Application No: EP/167/21/HH
Site Address: 2 Vicarage Lane East Preston BN16 2SP
Description of works: Erection of single storey rear and side extensions with mono pitched roofs and installation of fencing to front and side.

Thank you for your internet representation made on 25th January 2022 which has been recorded as an objection with the comments as follows:

The Planning & Licensing Committee of this council considered this Application at its meeting on Monday, 24th January.

Client	Mrs Grace Morgan
Project	2 Vicarage Lane
Sheet	Fence Elevations

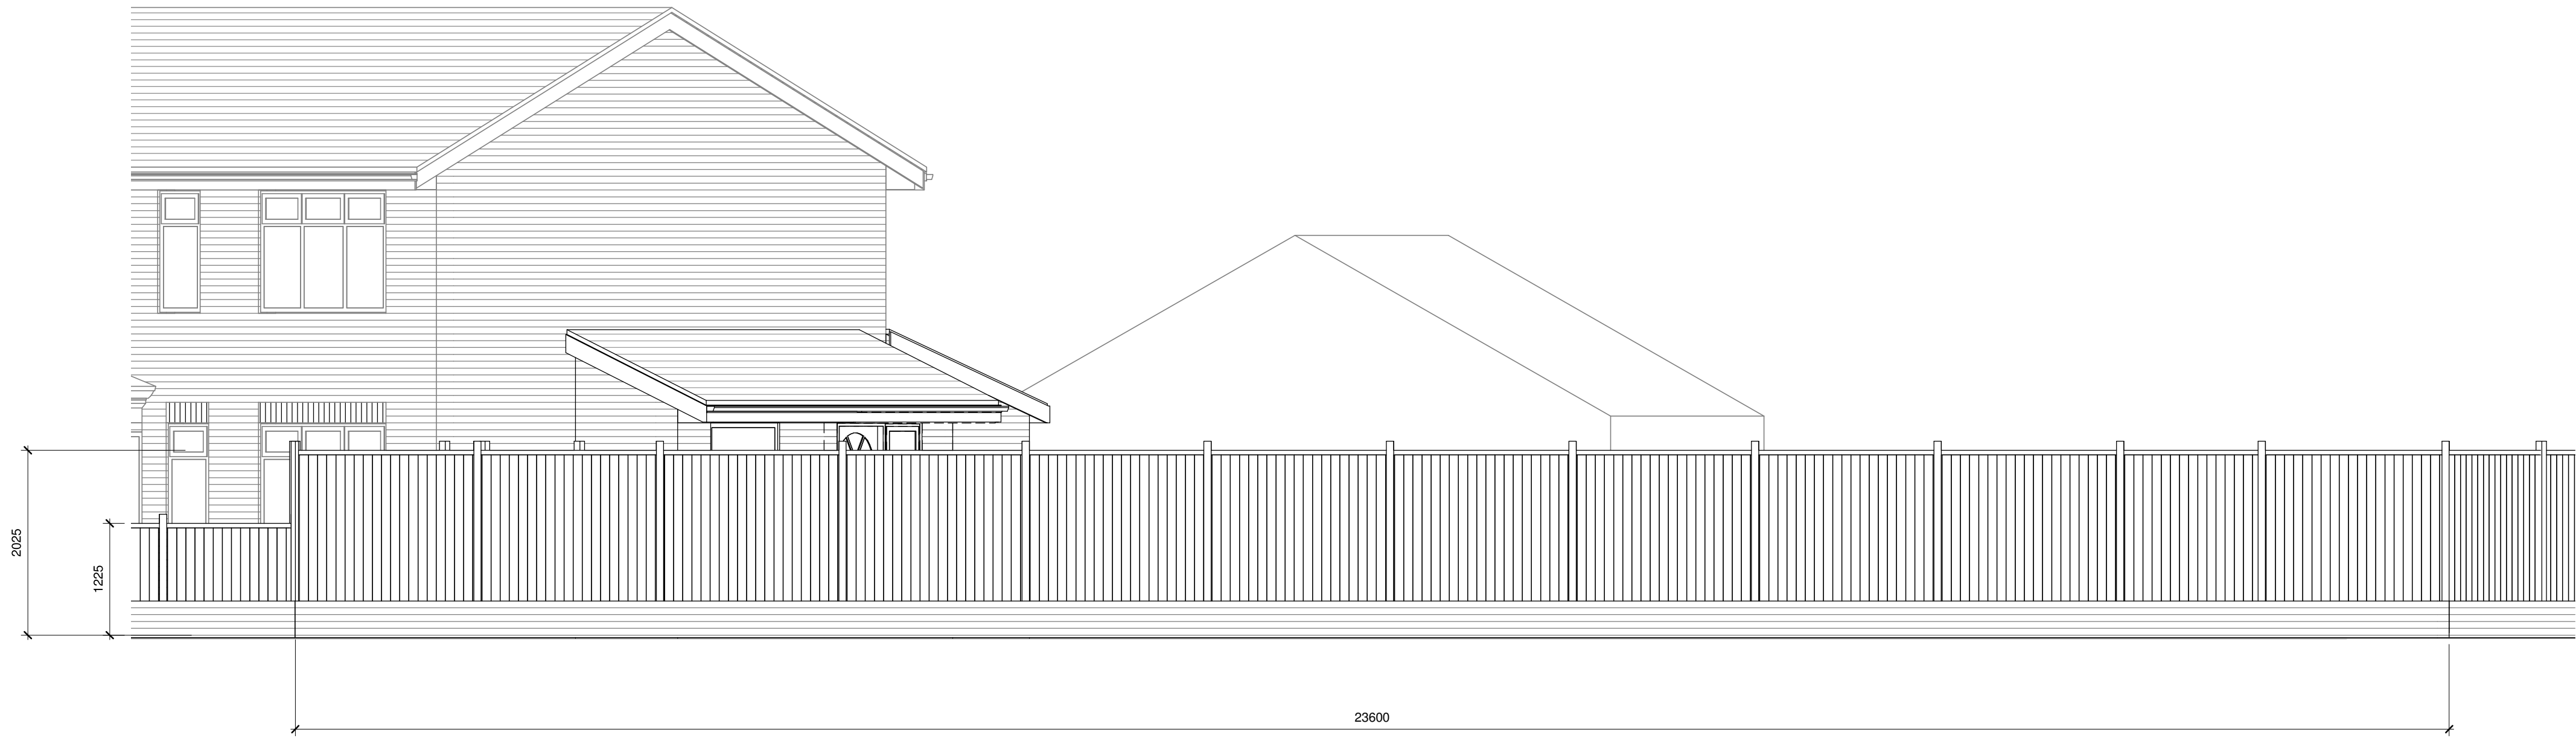
The committee has no objections to the proposed extensions but it did agree to object to the proposed 2m high fence. The property is in a relatively open-plan part of the village, characterised by low-level boundary walls. There are several examples in Vicarage Lane where additional screening has been provided this has been with hedging rather than fencing. Hedging encourages biodiversity too. This property is on a prominent junction. The proposed fence would be overbearing and out of keeping with neighbouring properties. This would be contrary to the East Preston Neighbourhood Plan and Policy D DM4 of the Arun Local Plan which asks an "alteration does not compromise the established spatial character and pattern of the place".

For these reasons, the council asks ADC to refuse Planning Permission for the proposed fence.
